Permit Number: 030838

Proposed Project Description:  
Replace Existing Handicap Ramp with a Concrete Ramp

Re: MMC Engineering Building Ramp Replacement

Section A1/S1

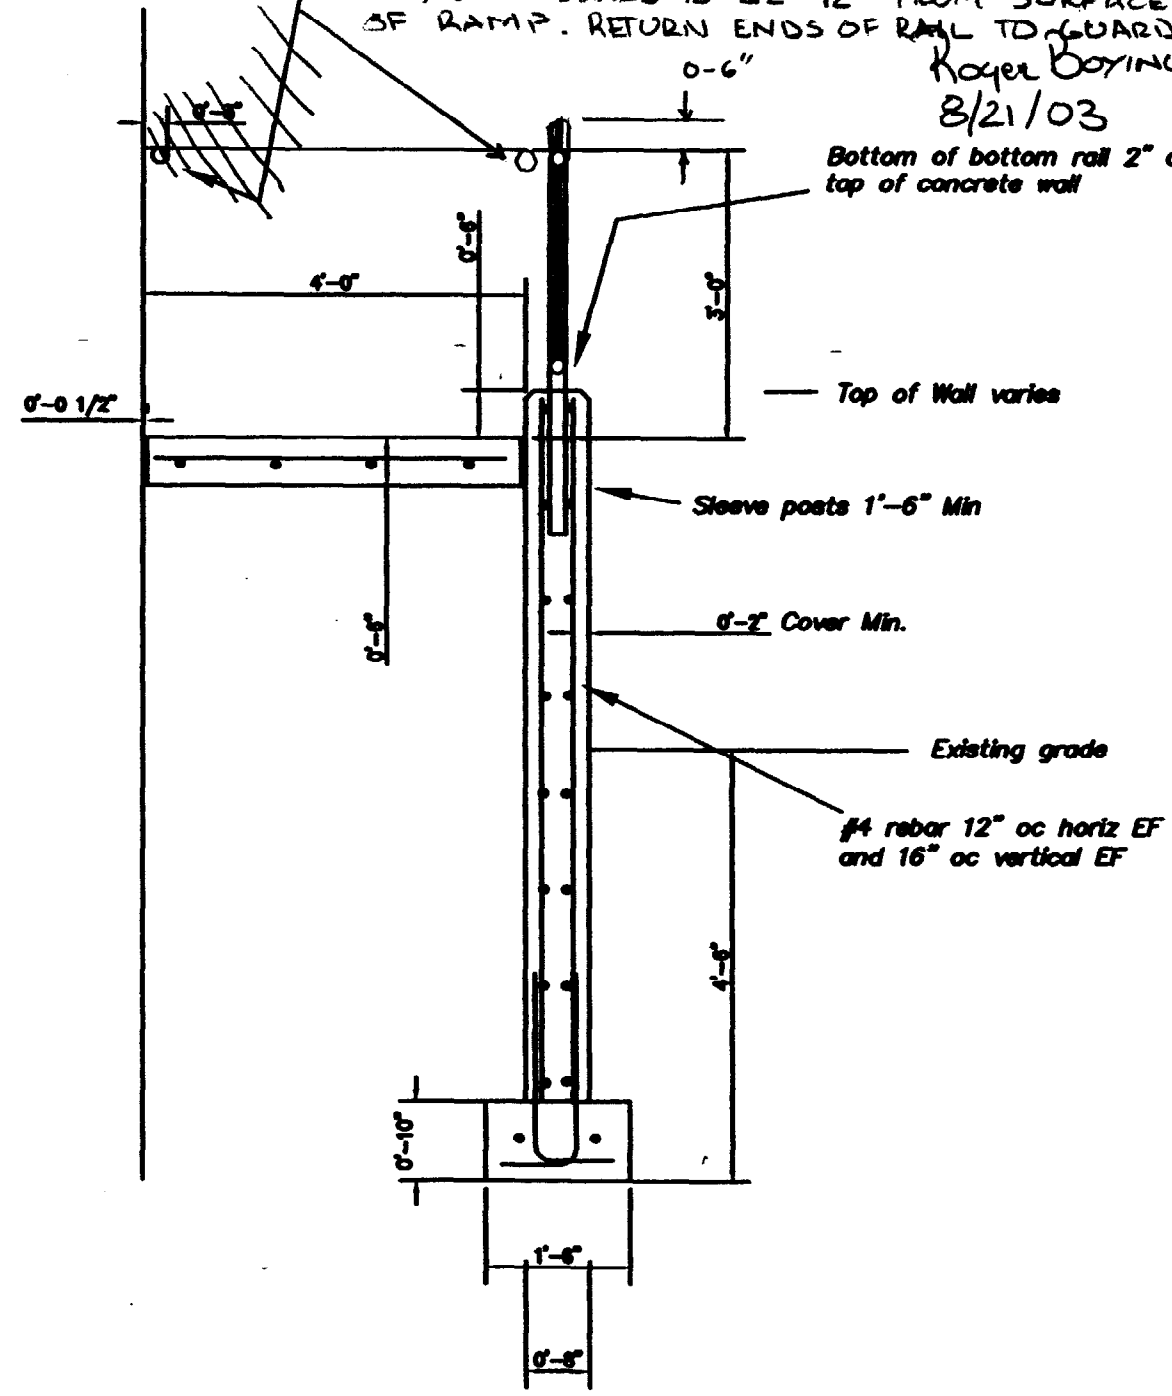
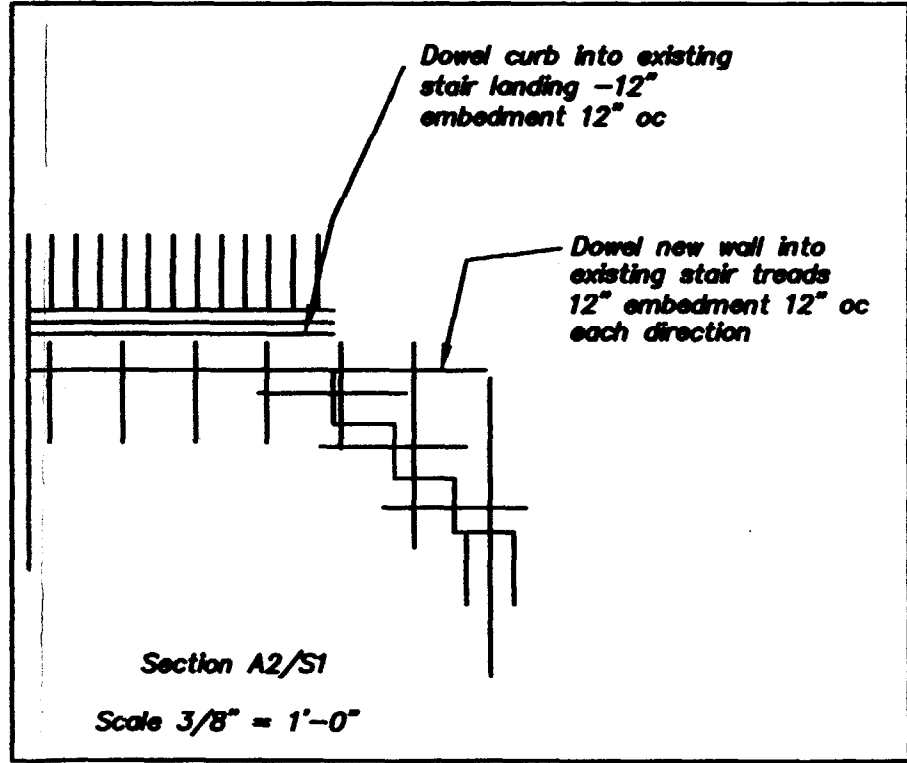
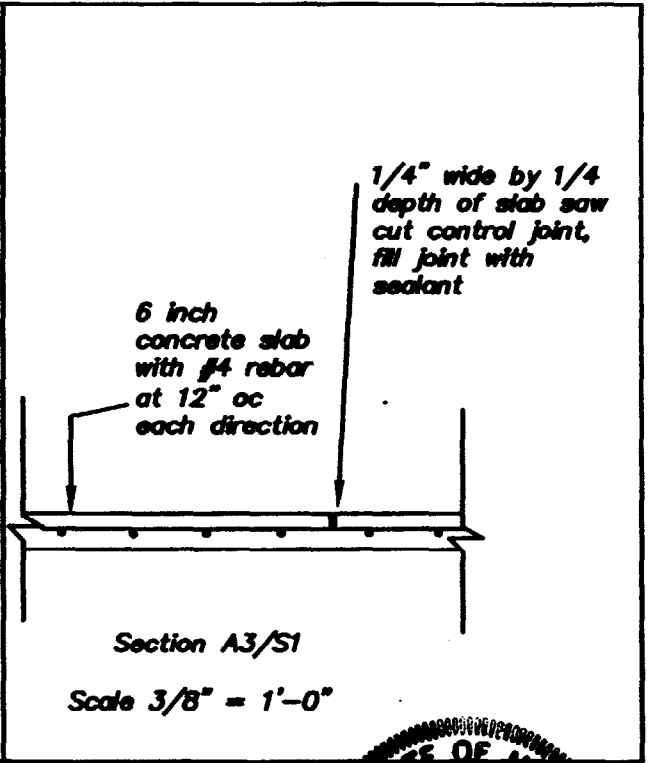
<b>Comments:</b> 7/23/2003-mjn: Guards must be 42" in height, 36" shown, left message with contractor
--
